**From:** Lyndsey Hayes  
**Sent:** 28 February 2024 13:44  
**To:** Lyndsey Hayes  
**Subject:** Tilia Homes response to LLFA objection

**From:** [REDACTED]  
**Sent:** Monday, February 26, 2024 5:46 PM  
**To:**  
**Cc:**  
**Subject:** RE: Preston Road, Longridge  
**Importance:** High

Thank you for issuing through the LLF formal comments received on Friday 23<sup>rd</sup> February, in relation to our discharge of conditions application (Application No: 3/2020/0042). We have consulted with our engineering consultants at Lees Roxburgh and can confirm the following formal response to the comments received from LLFA as follows in **GREEN** text below, in relation to each respective condition:

A1 @ NTS - Preston Road - 40%cc + 10% Urban Creep added to Phase 3 - 6196

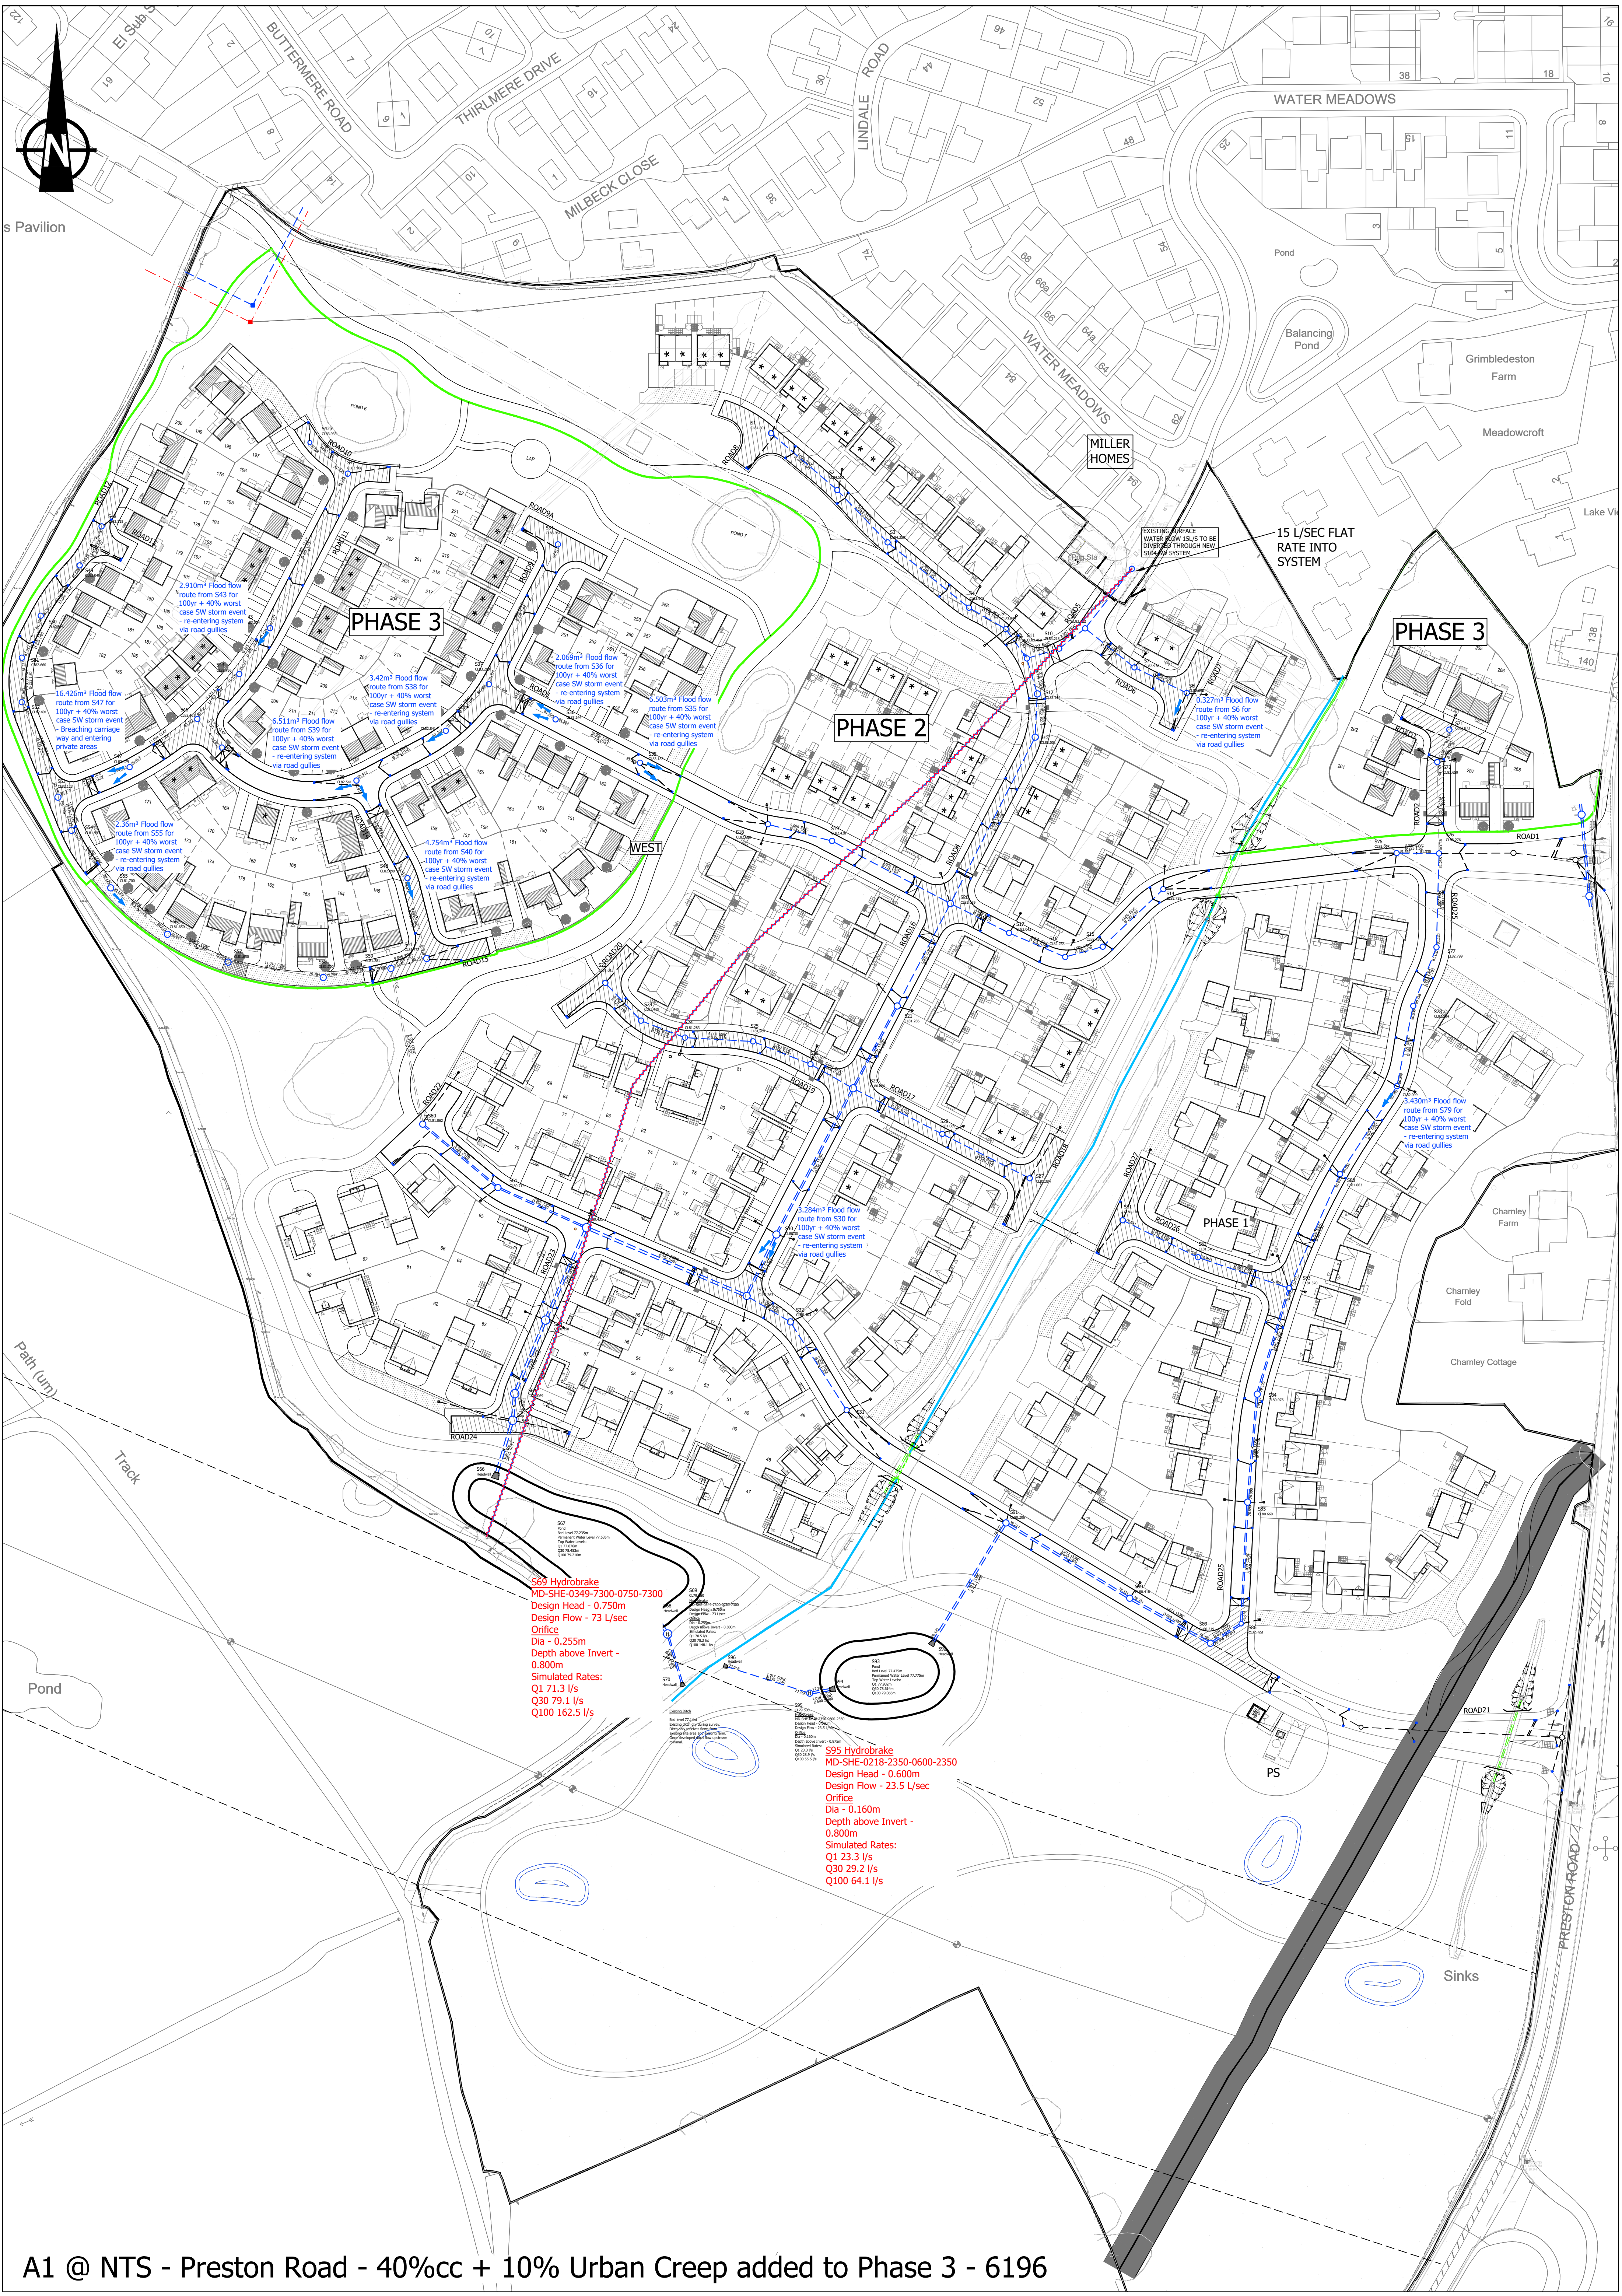
- *The applicant has failed to provide evidence of the drainage plan showing flood water exceedance routes in accordance with Defra Technical Standards for Sustainable Drainage Systems.*

Please see attached the **Drainage Proposals Plan (Ref: 6196/01-07 REV M)**, which details the requested flood water exceedance routes to the drainage proposals, which accompany the **Drainage Statement document (Ref: 6196/R2 Rev F)** submitted as part of our planning application.
